Re: **Roof Truss Item**
Location: Lot 86 Providence Creek (Fuquay-Varina, NC)
JDS Project No.: RDU2207025
Date of Inspection: 07/12/22

A representative of JDS Consulting arrived on site to observe the issues reported to us by the client, which are presented, along with our recommendations, in this report.

| Job<br>PERMIT | Truss<br>A02 | Truss Type<br>MONO HIP | Qty<br>8 | Ply<br>1 | MATTAMY HOMES/TETON | 150628427 |

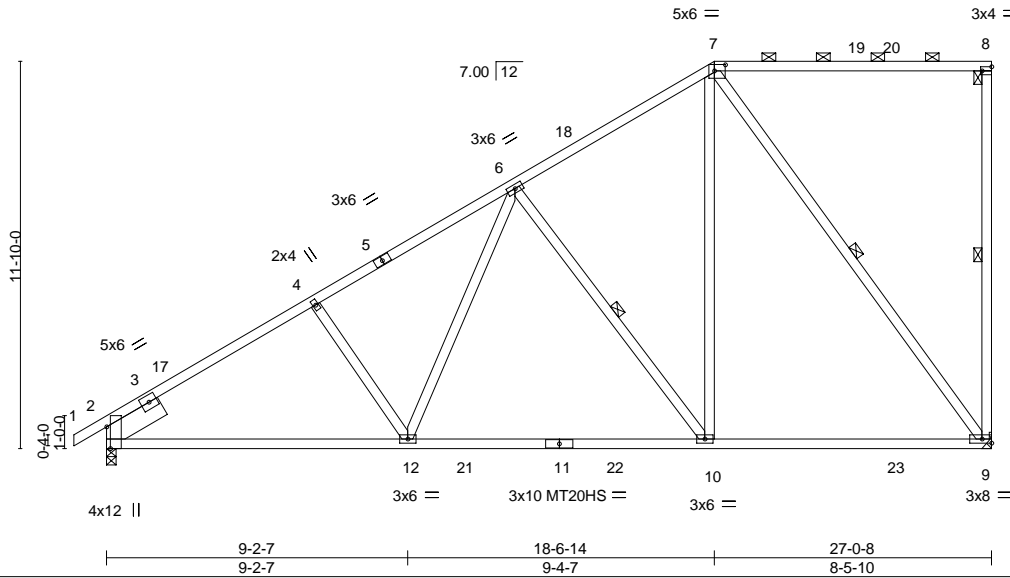
The 2nd truss from the right gable, A02, at the owner's bedroom above the door to the bath has a 3' section of the bottom chord missing.

Based on our onsite observations and review, cleanly cut the damaged ends of the bottom chord square. Then, install a 2x4 cut to fit tightly to the squared ends of the bottom cord with (1) 10D toenail in the top and bottom at the new splices. Next, add an 8' 2x4 scab extending a minimum 2' past the new splices in each direction and attached with (2) 10D nails at 4" o.c. on each side.
